Application No: LU/50/21/PL
Site Address: Littlehampton Promenade South of Putting Green Sea Road Littlehampton
Description of works: Provision of 20 No. new beach huts on concrete bearers to broadly match existing.
This site is in CIL Zone 5 (Zero Rated) as other development.

Thank you for your internet representation made on 27th April 2021 which has been recorded as an objection with the comments as follows:

Arun District Council Beach Hut Application
Block Plan (West Part). Scale 1:500 @ A3
Red Rectangles Represent Proposed Positions

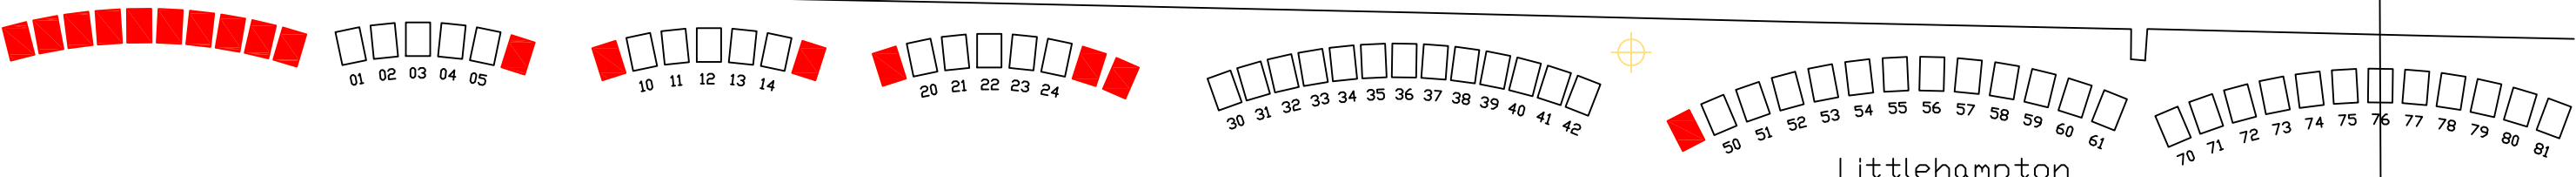
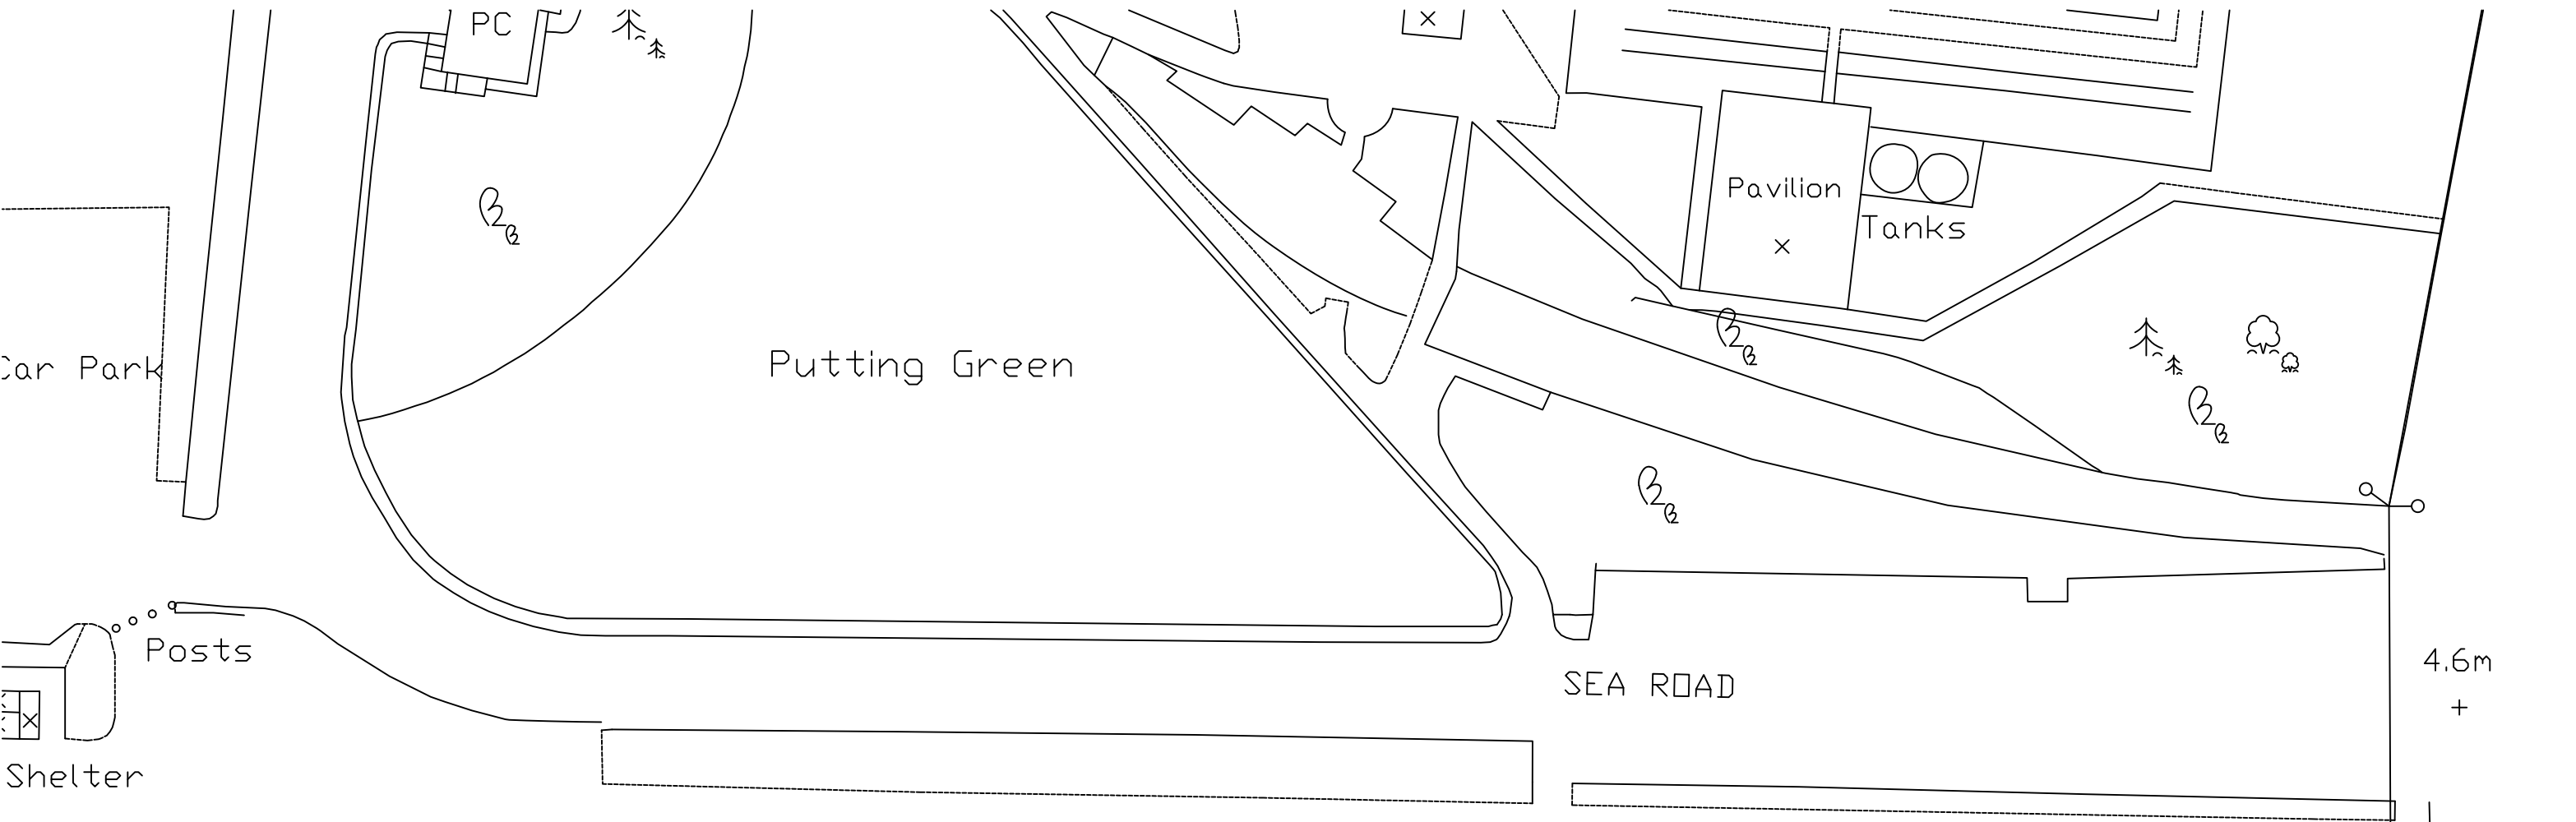
Firstly, My husband and I own beach hut number one, the nearest to the East Beach Cafe, on the end of row 1 to 5. Your construction plans for the 10 new west huts show a disproportionate gap between us and the new huts in comparison with the other blocks along the beach and advise that this gap should be equidistant as all the other blocks.

Secondly, rather than 10 huts west of our hut number one, two sets of 5 would be more attractive and welcoming to visitors in cars approaching the seafront from the north as they would have a view of the sea between the gaps. Also this would make it easier for families joining the beach directly from the car park behind the East Beach Cafe. Especially those with wheelchairs and pushchairs.
